CITY OF PORTLAND BUILDING PERMIT

Located At 43 QUEBEC ST

Job ID: 2011-11-2677-ALTR

Jonathan Rioux - RE: 43 Quebec Street Addition- LandMarx Construction

2nd FLOOR PLAN

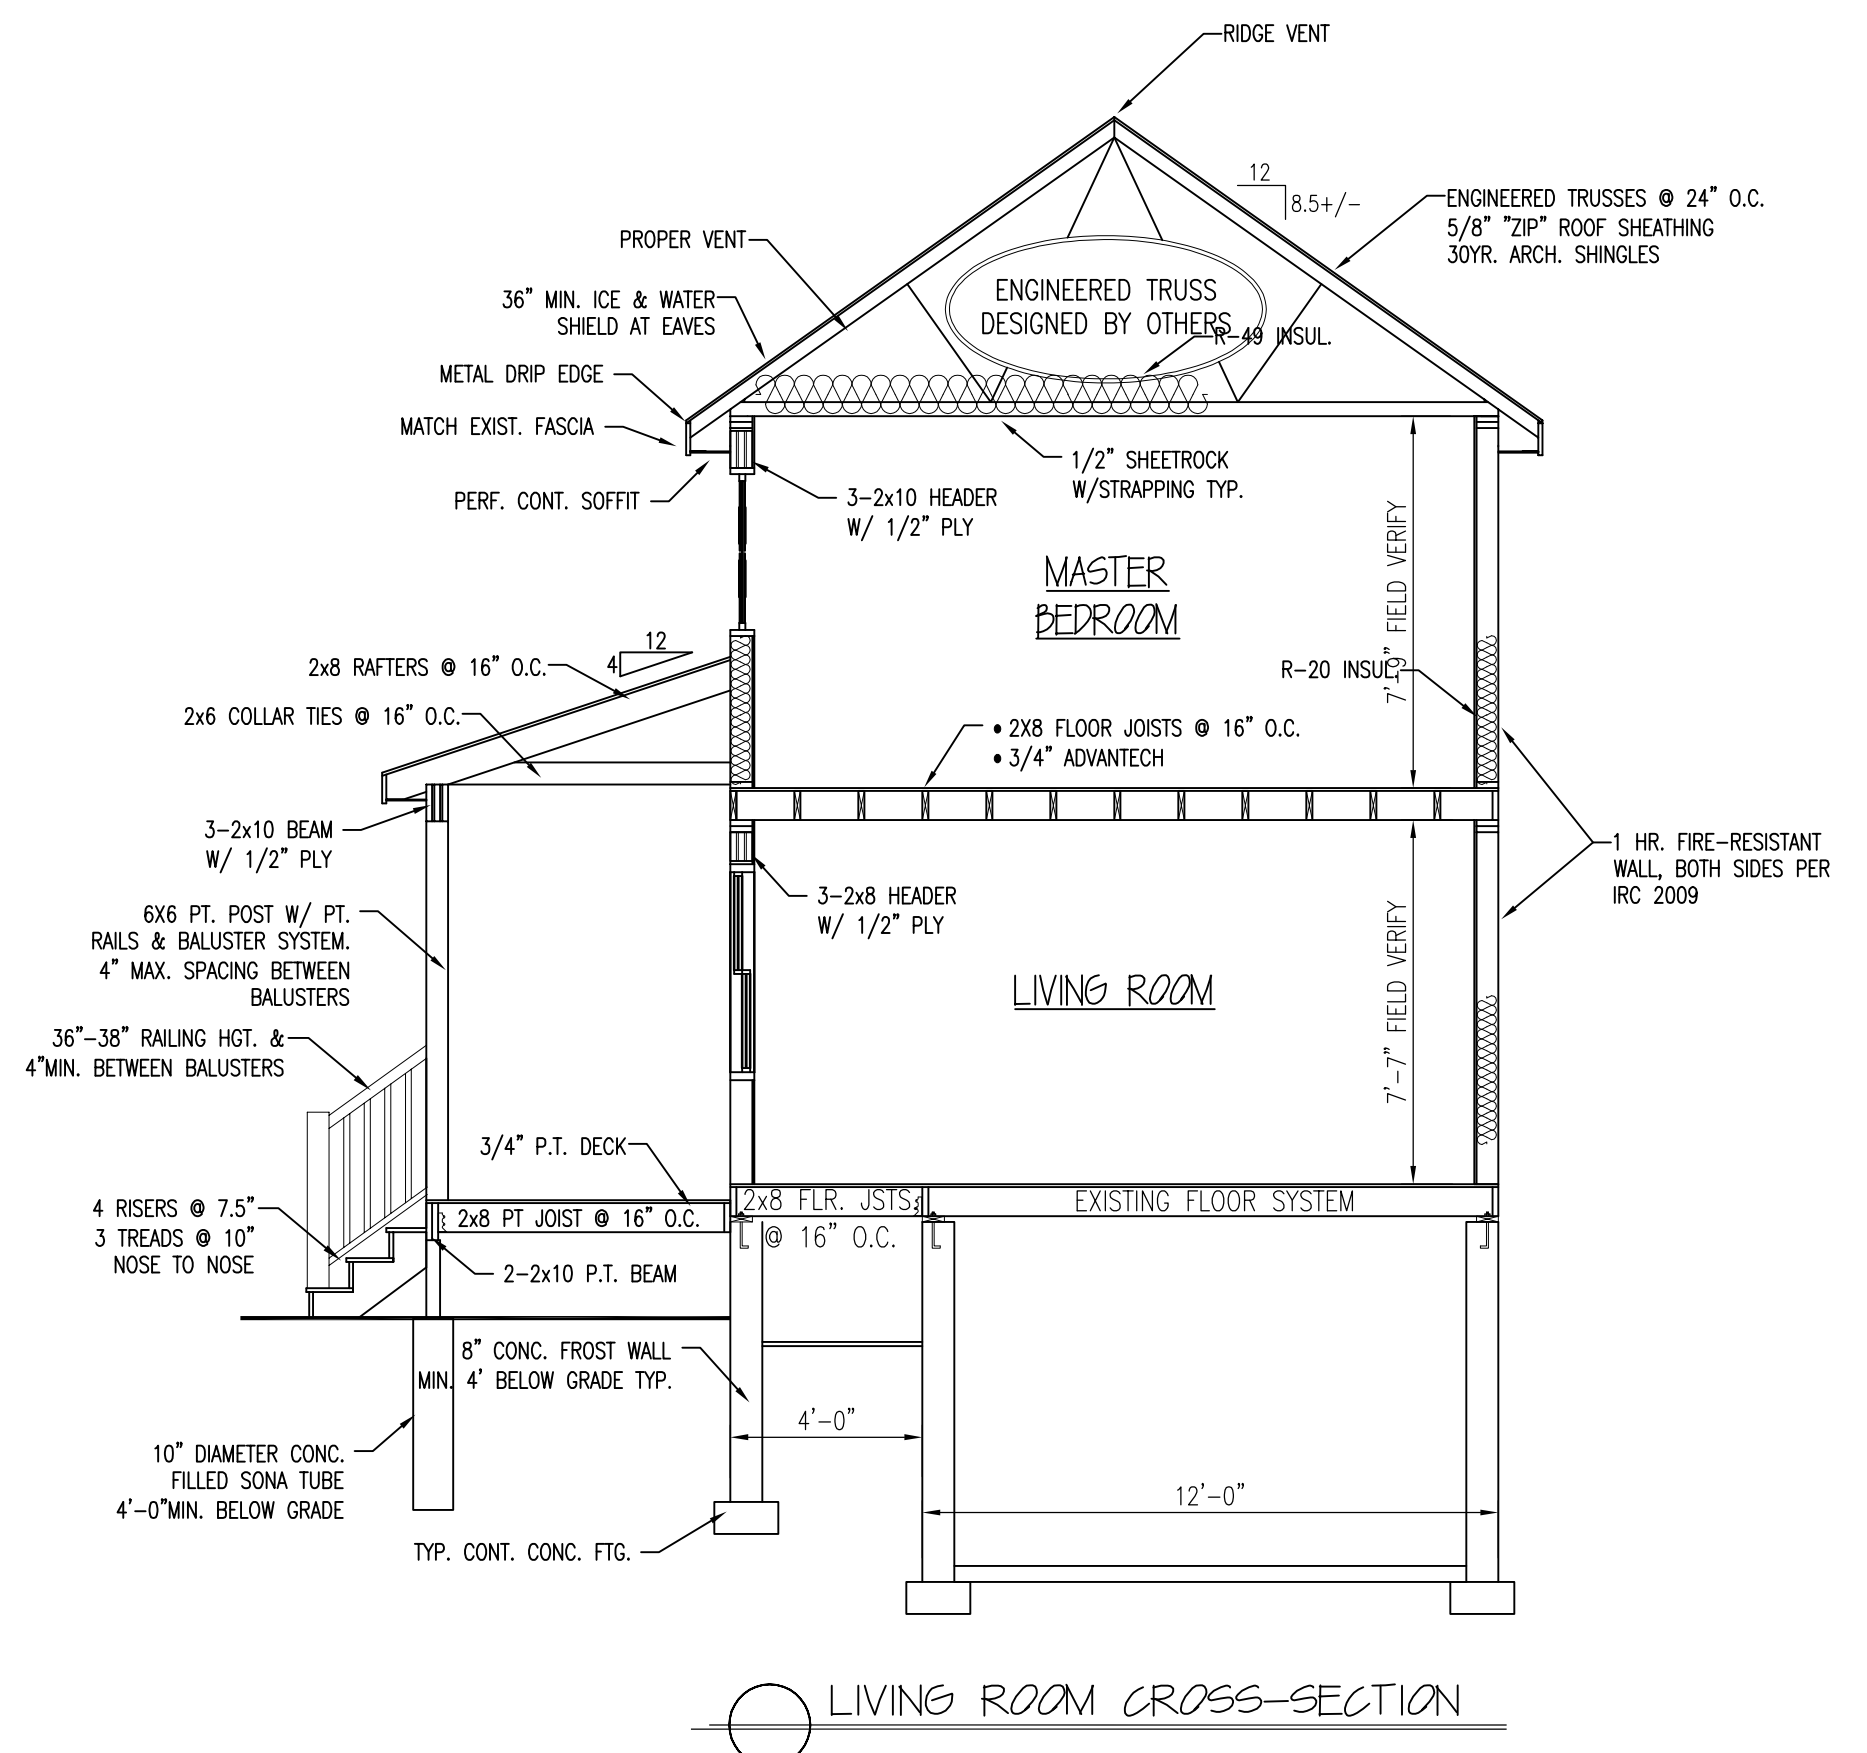
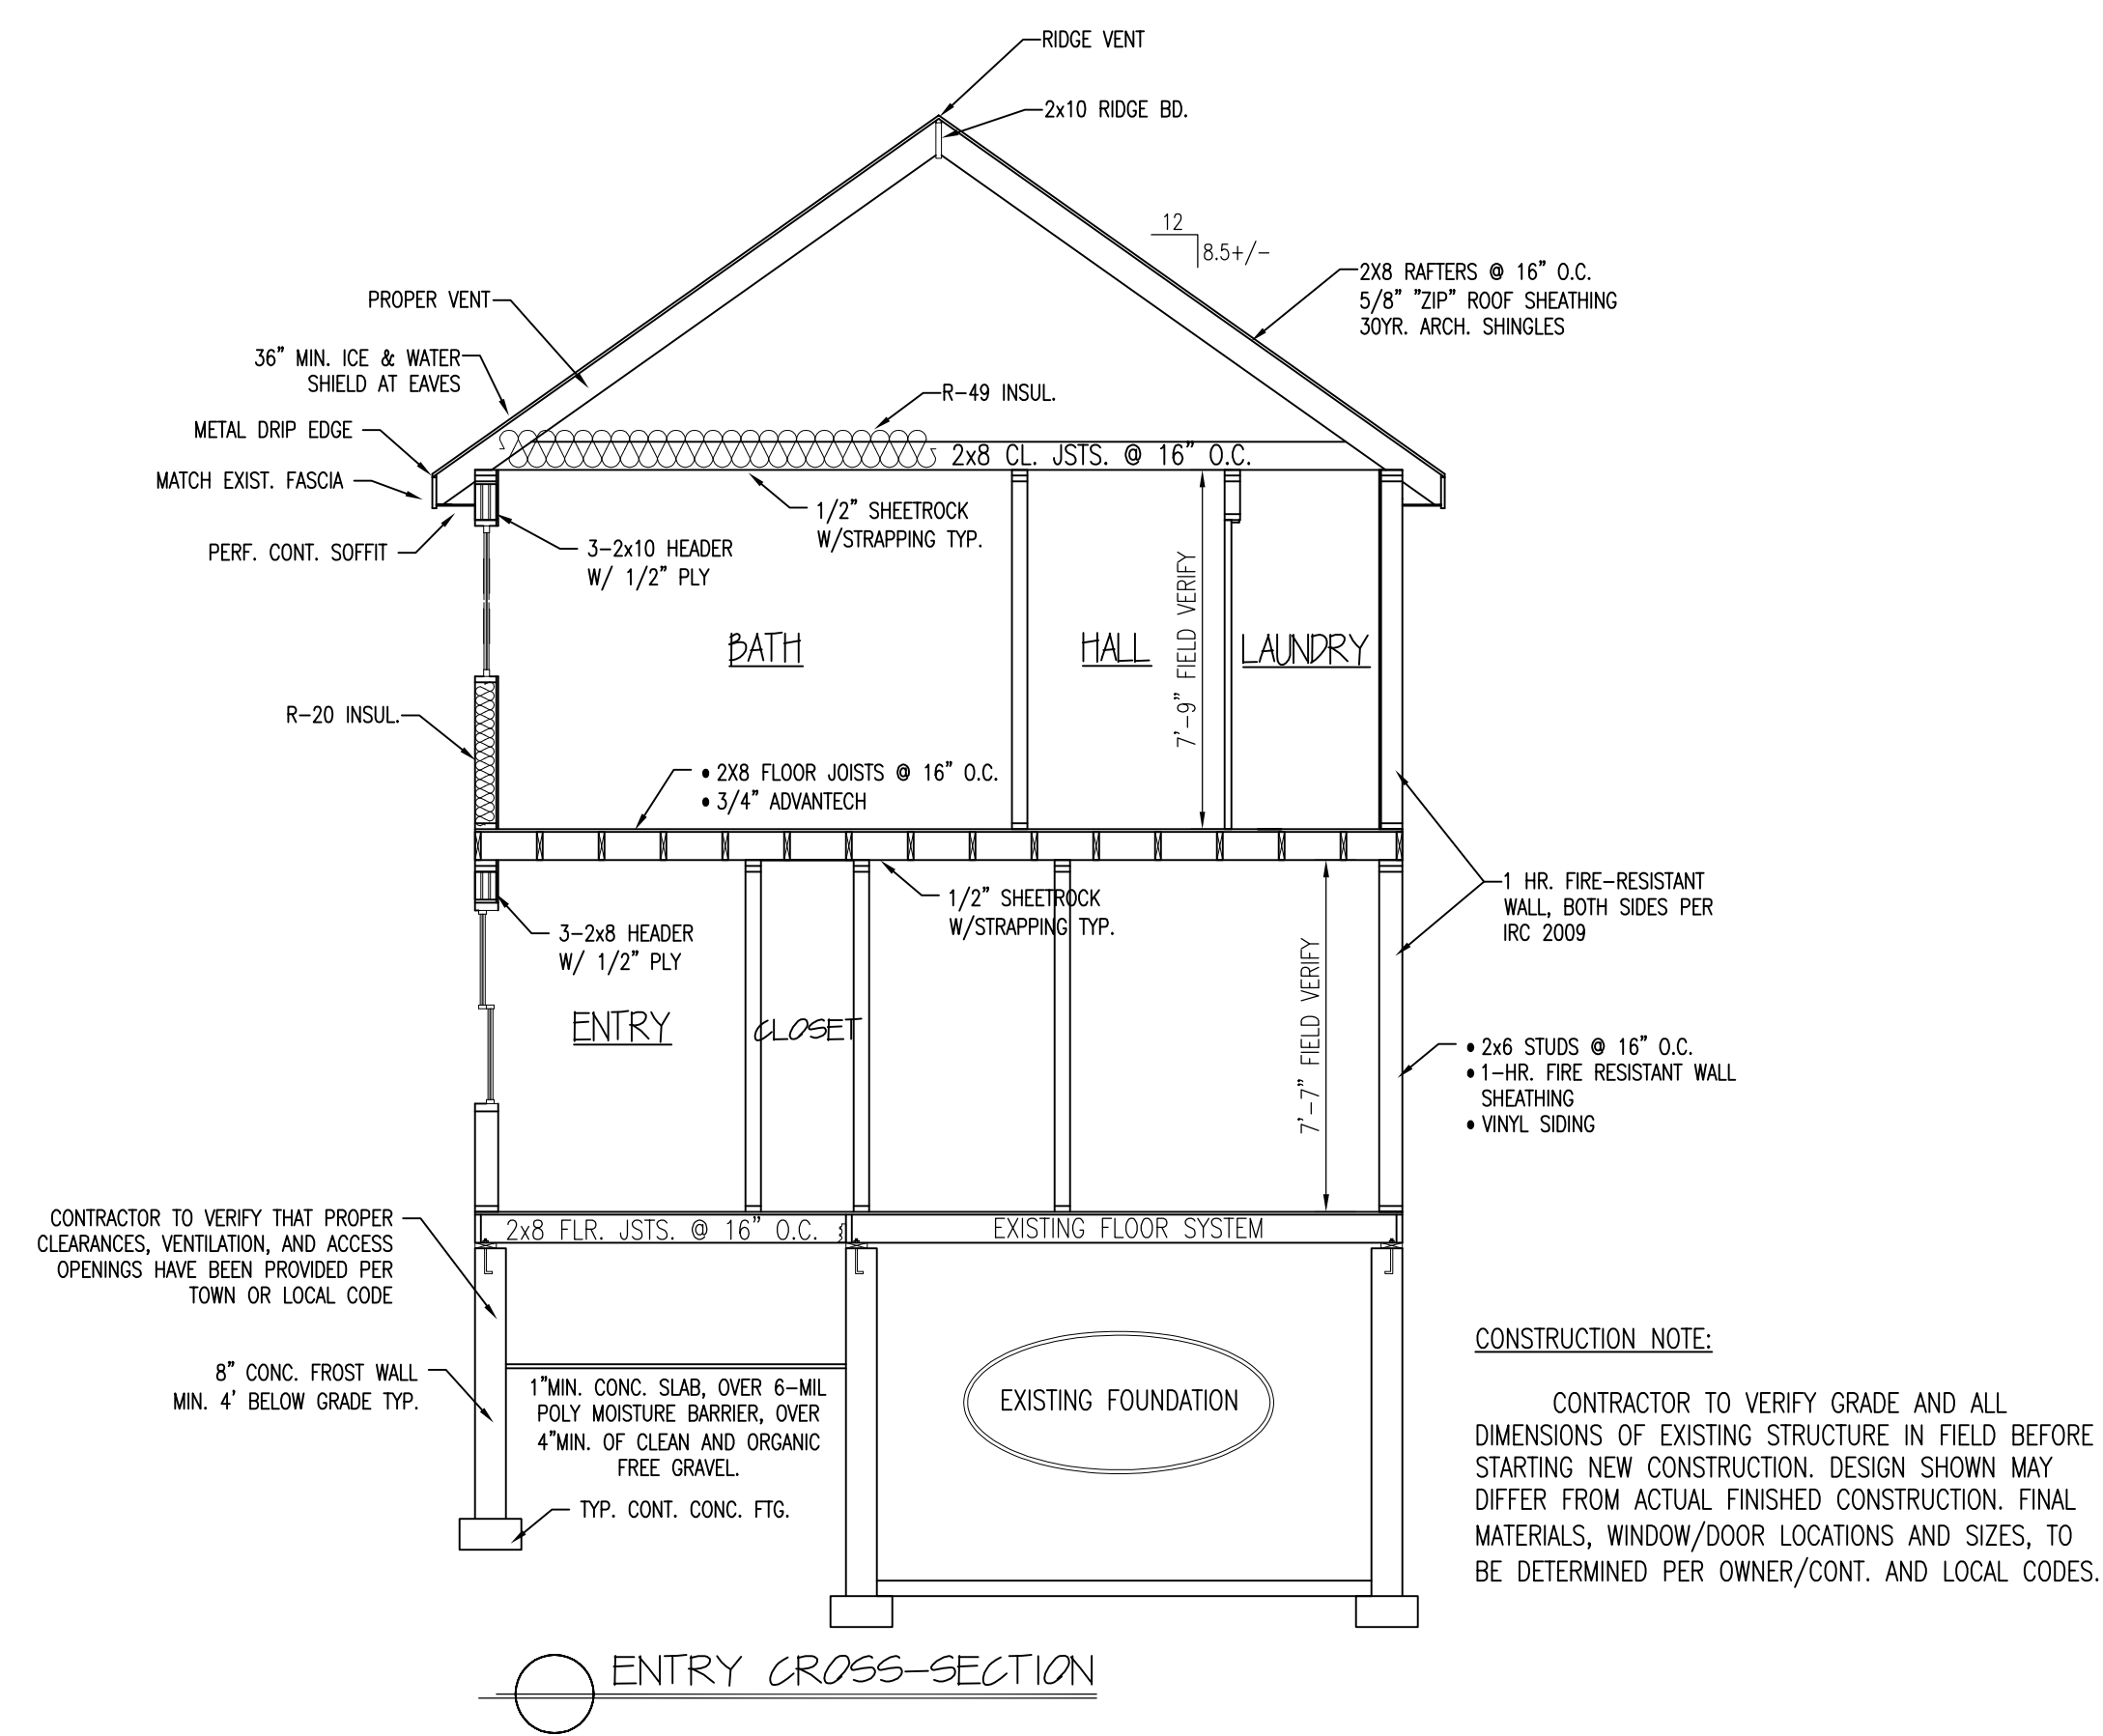
- A Second Floor to Foundation- Floor Plan showing how far the 2 X 8 inch joist are spanning w/ a cross section of the center Girder (if any).
- A cross section of the slopped second floor bathroom ceiling (showing fixture clearance headroom), see Section R305.1.
- What materials are being used for the 1 Hour Wall, see Section R302?
- How far are you spanning the (2) 2 X 10 Inch Beam between each Sona tube, see Table R502.5(1)?
- Is the interior stairwell changing to the new addition?
- Jonathan Rioux
 Code Enforcement Officer/ Plan Reviewer

- A Second Floor to Foundation- Floor Plan showing how far the 2 X 8 inch joist are spanning w/ a cross section of the center Girder (if any). Dimensions have been added to the floor plan and notes added to existing cross-section
- A cross section of the sloped second floor bathroom ceiling (showing fixture clearance headroom), see Section R305.1. – the only sloped clg. In the bathroom is in the corner where the linen shelves are, thus no fixture clearance issues- see plan & section.
- What materials are being used for the 1 Hour Wall, see Section R302? Notes have been added to x-sxn & floor plans
- How far are you spanning the (2) 2 X 10 Inch Beam between each Sona tube, see Table R502.5(1)? More Dimensions have been added to floor plan
- Is the interior stairwell changing to the new addition? No changes here.
